Ribble Valley Borough Council  
Church Walk,  
Clitheroe,  
BB7 2RA

Phone: 0300 123 6780  
Email: [lhscustomerservice@lancashire.gov.uk](mailto:lhscustomerservice@lancashire.gov.uk)  
Your ref:  
Our ref: LHS/CS/3/2016/0182  
Date: 23<sup>rd</sup> March 2016

<b>Proposal:</b>	Proposed two storey side extension and single storey rear extension.
<b>Location:</b>	26 Holden Street Clitheroe BB7 1LU
<b>Grid Ref:</b>	374676 - 441901

Proposed ground floor plan

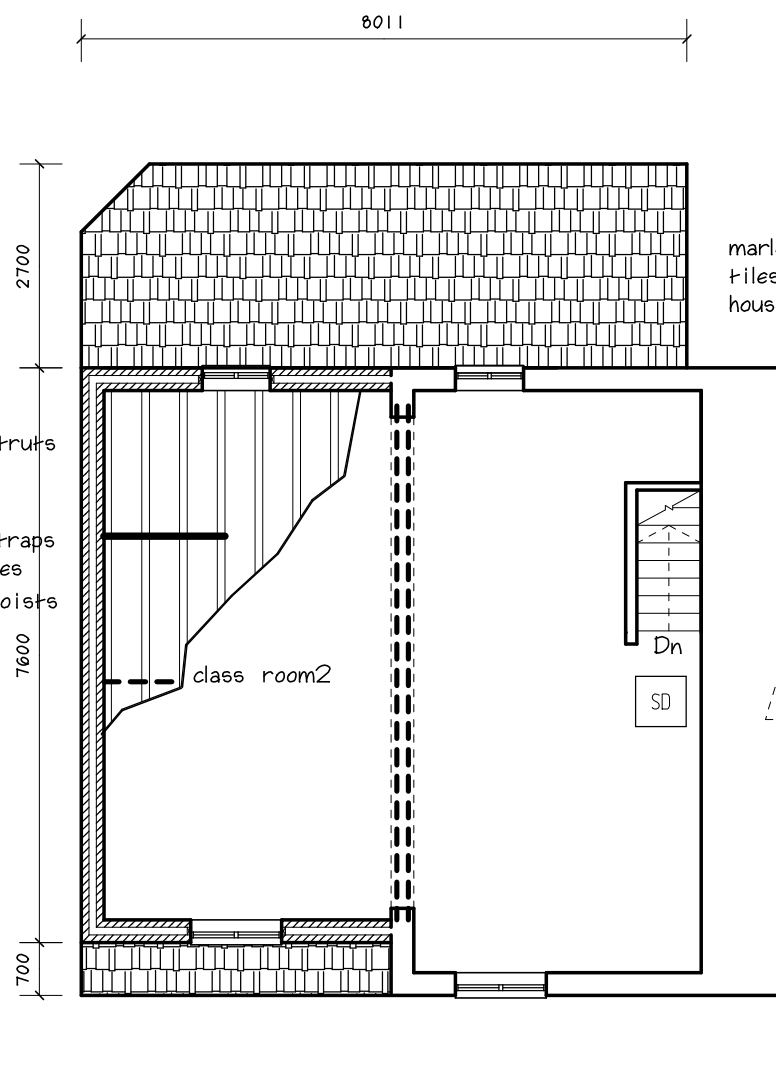
From our highway adoption records, part of the development is over the adopted highway associated with River Lea Gardens. This area of highway would need to be stopped up under section 247 of the Town and Country Planning Act. The stopping up will need to be agreed with the legal section at Ribble Valley Borough Council, before works begin on site. I have attached a plan showing the extent of the adopted highway in green.

1. Before any construction works begin on site the area of existing adopted highway associated with the approved development is to be stopped-up under section 247 of the Town and Country Planning Act. Reason: to protect the users of the adopted highway and allow for the effective use of the parking areas and refuse storage for the residents without causing an obstruction of the highway.
2. The car parking and manoeuvring scheme to be marked out in accordance with the approved plan, before the use of the premises hereby permitted becomes operative and permanently maintained thereafter. Reason: To allow for the effective use of the parking areas.
